Y/105/19/PL & Y/106/19/L

The proposal is for the conversion of, and alterations to, existing barns to create 3 dwellings, along with the erection of car barns, a store, a replacement pump house, demolition of a C20 barn and associated landscaping and parking.

Proposed North Elevation (A)

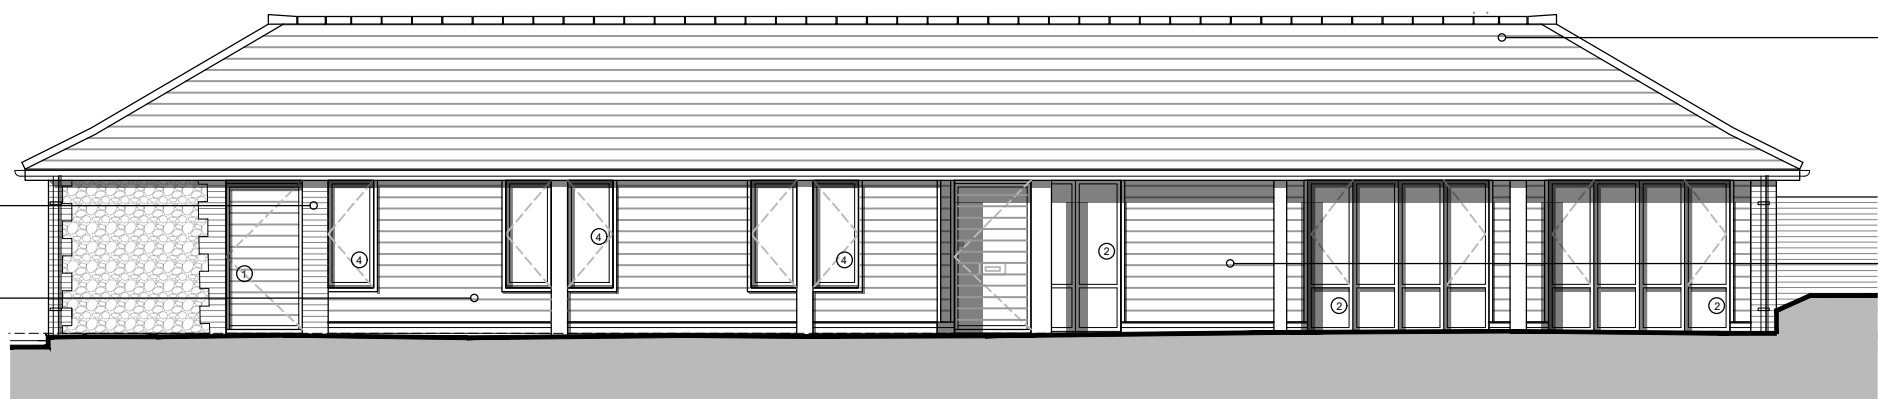
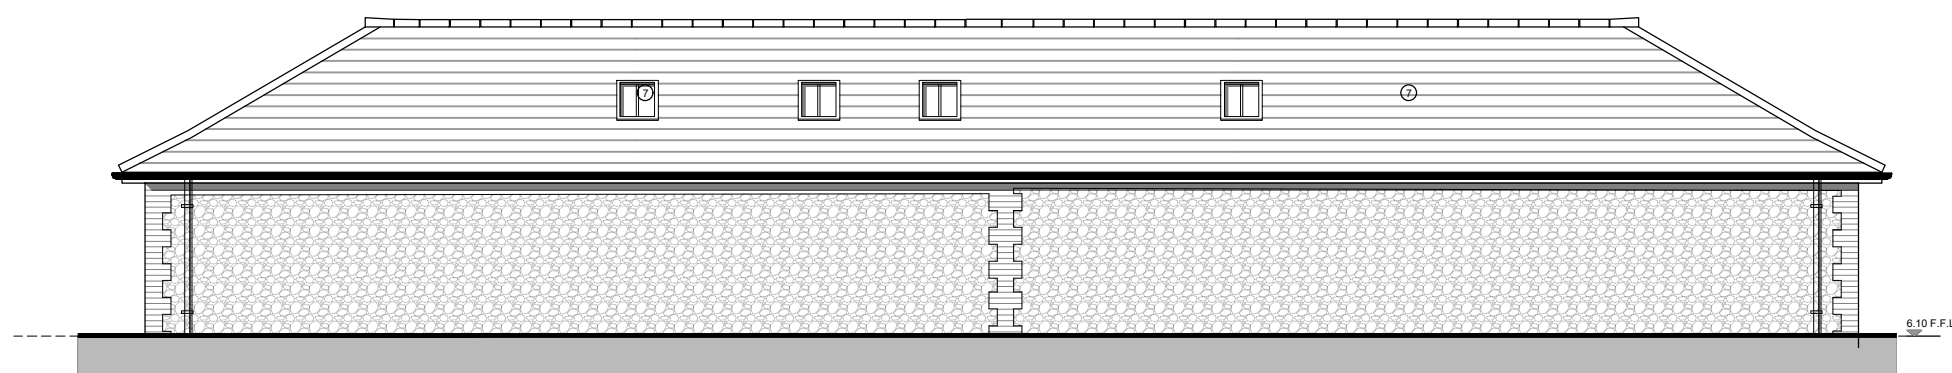
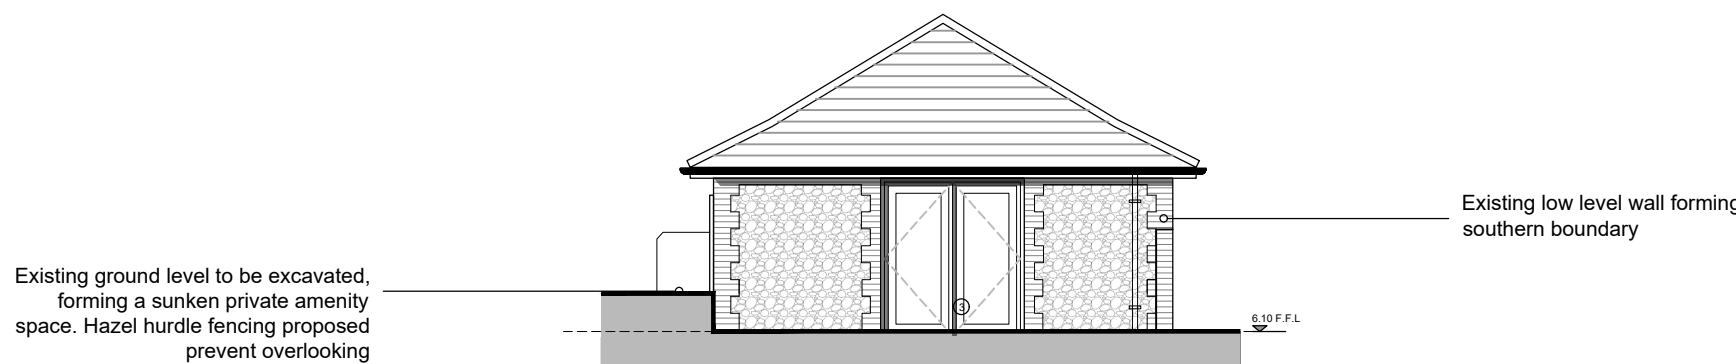
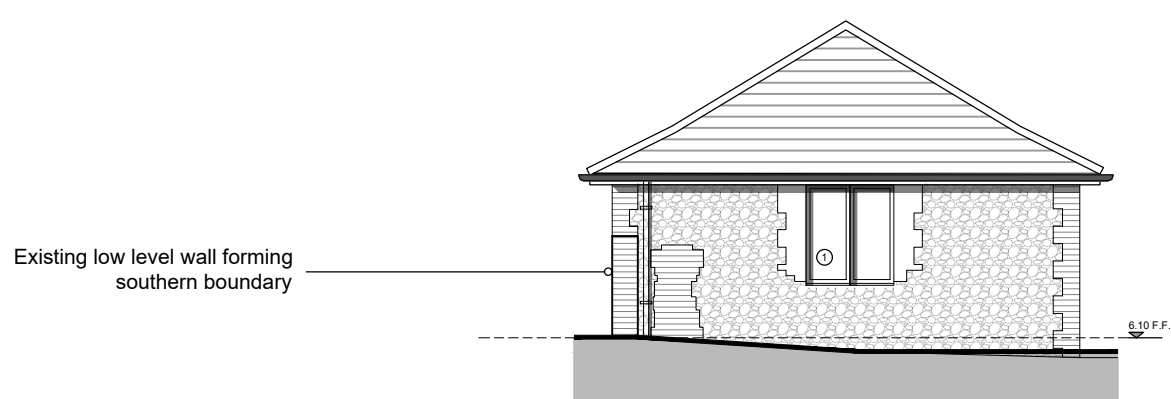
Likewise, it is noted that the building referred to as 'barn 3' is to include bi-folding doors. Such a feature is not normally associated with a barn and cannot be supported here. It is suggested that an alternative approach be considered which would result in the loss of less historic fabric, and a more appropriate design.

Yes, this can be altered to a pair of patio doors which will reduce the size of the opening in the exiting barn. Again, where new external openings are proposed we will look to repurpose the flint elsewhere in the scheme.
